March 20, 2017

**Re: TMobile Retail Building
2706 Carlisle Blvd NE
60-Day Temporary Certificate of Occupancy- Transportation Development
Engineer's/Architect's Stamp dated 10-26-16 (H16-D148)
Certification dated 03-13-17**

PROJECT TITLE  2706 CARLISLE BLVD. NE ALBUQUERQUE, NEW MEXICO 87110		JOB NO. 2016013		DRAWN BY: JEFF WOOTEN	
PROJECT MANAGER JEFF WOOTEN		SHEET TITLE Engineering Site Plan			
DATE: 9/2/2016		sheet: C1.1			
SCALE: AS NOTED		of 3

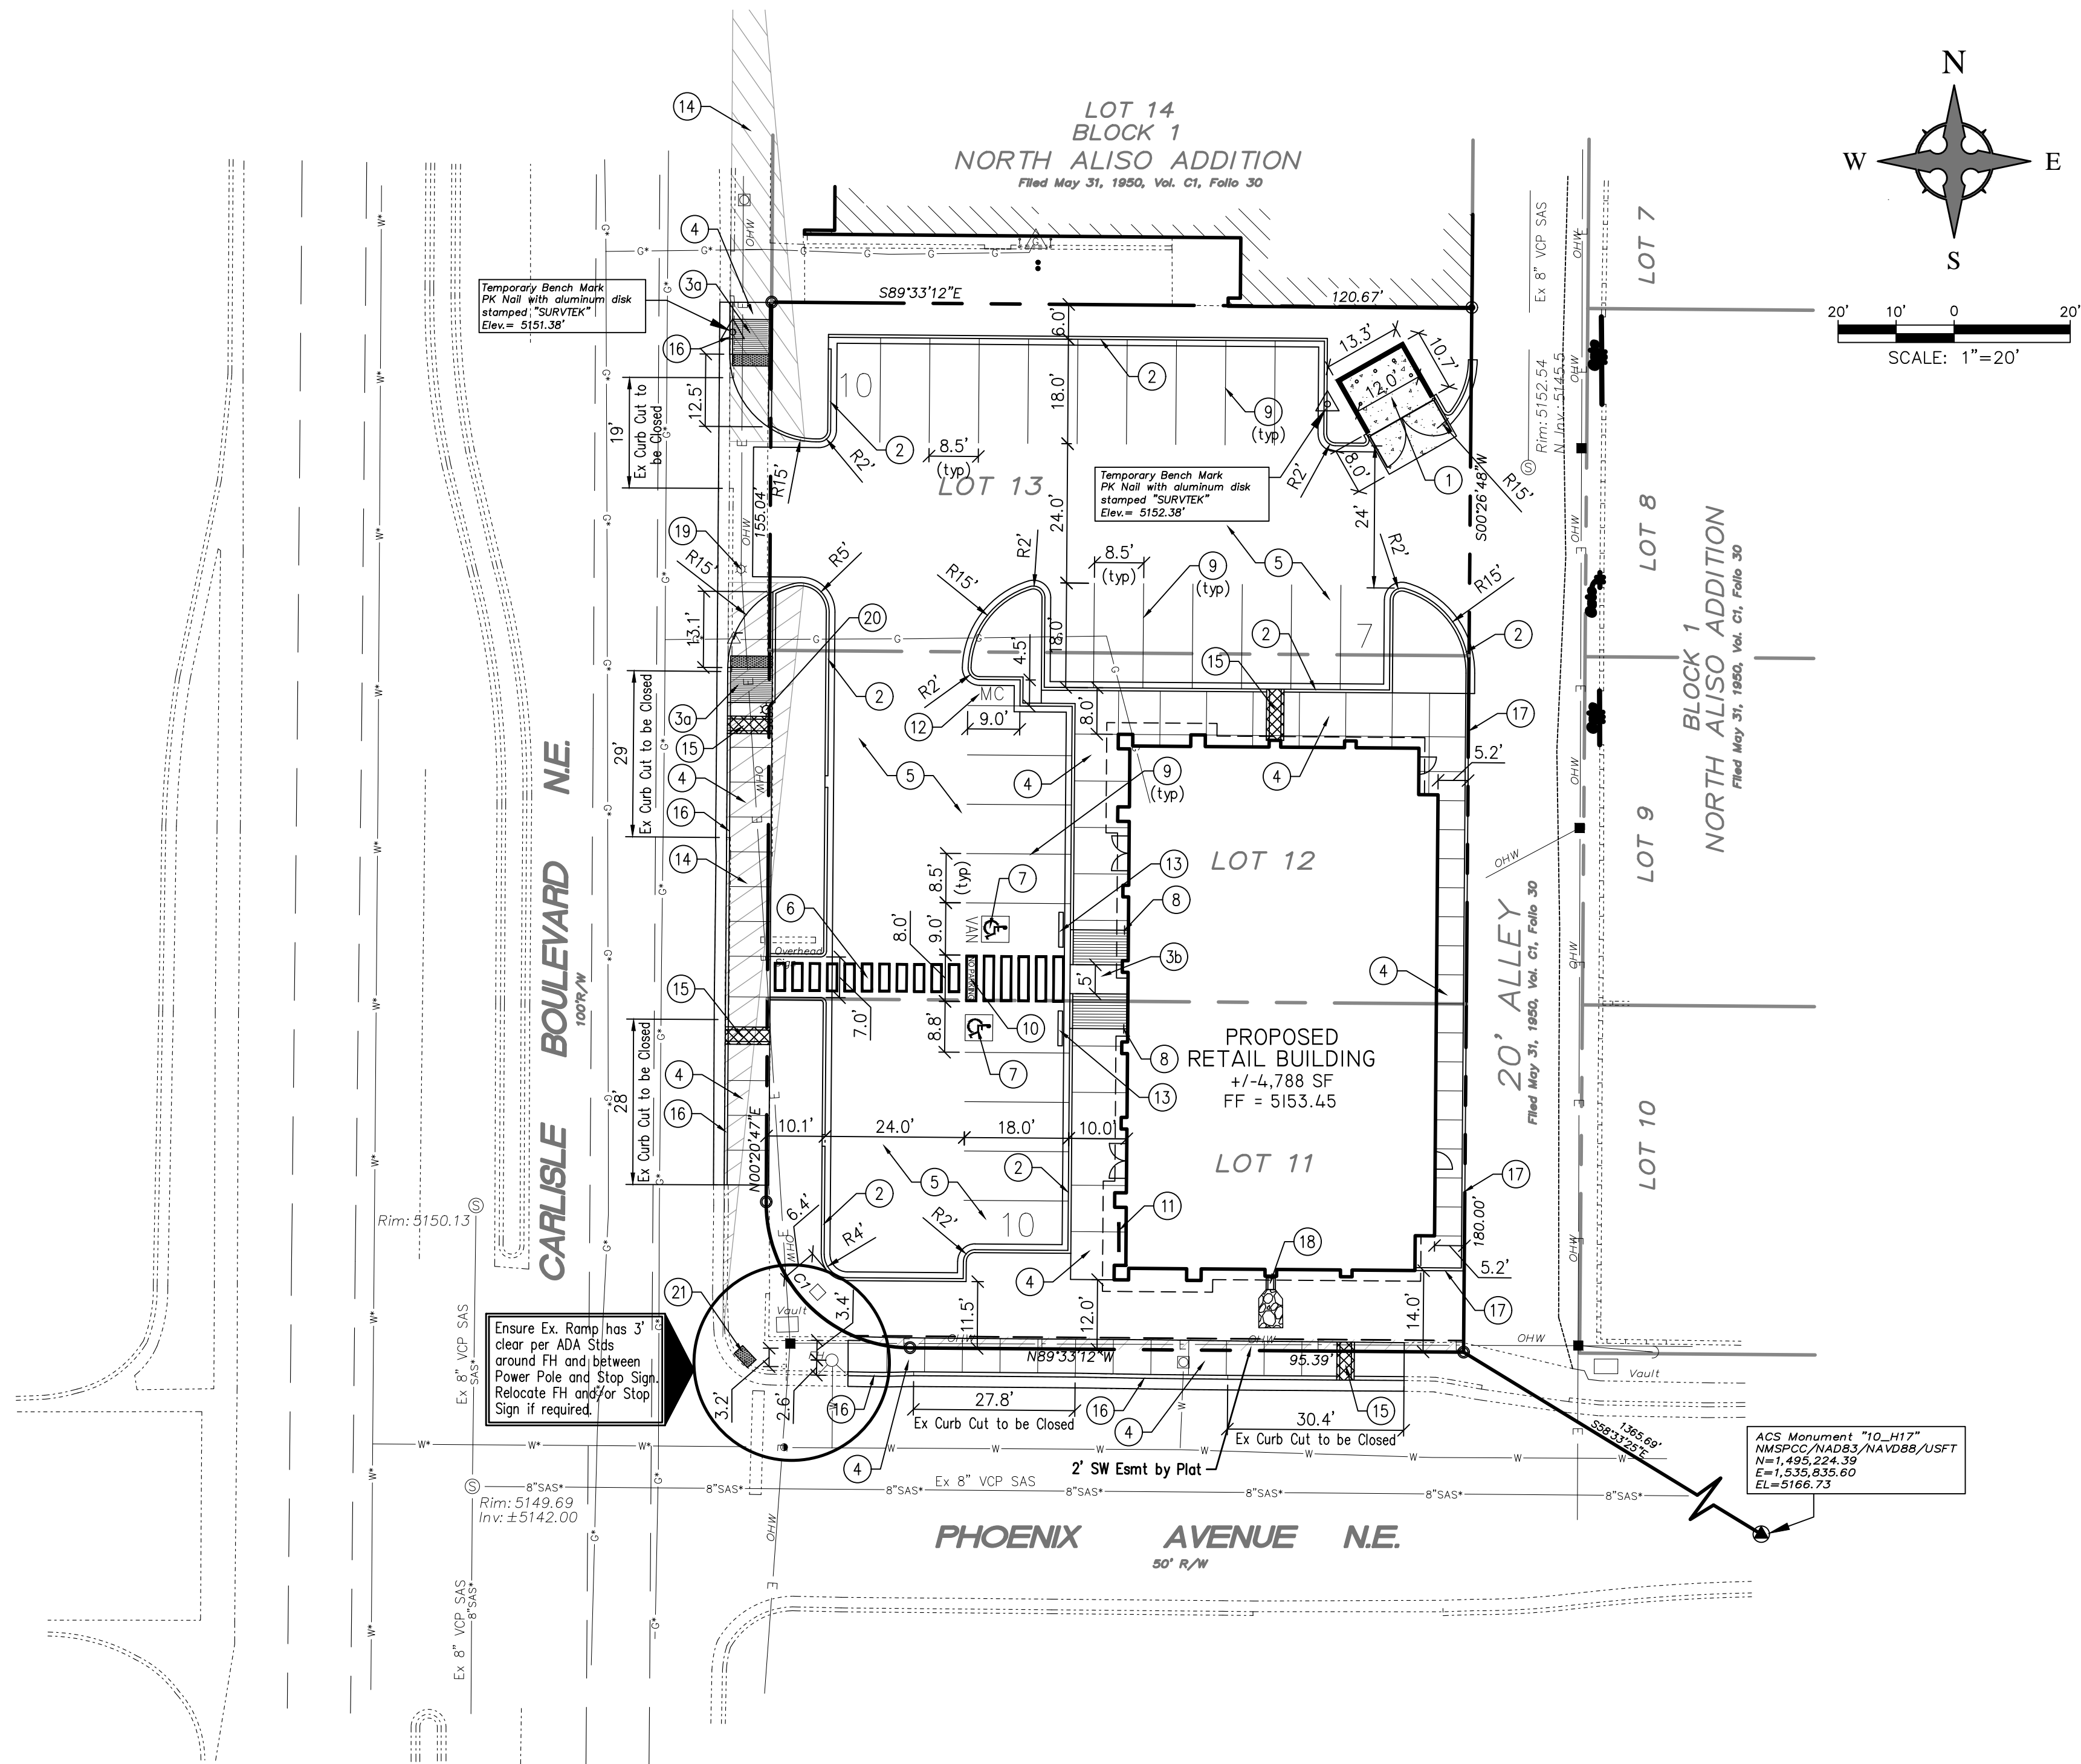
1. The pavement cuts on Carlisle next to the frontage need to be patched.
2. The alley along the property needs to be paved.
3. Normally we require a 6 foot pedestrian path from the Right of Way to the building. We will accept the 5 foot wide path for this development
4. Bike rack needs to be installed
5. The motorcycle parking space needs to be labeled with paint and signage added.
6. Detectable warning surface needs to be installed per key note 21.
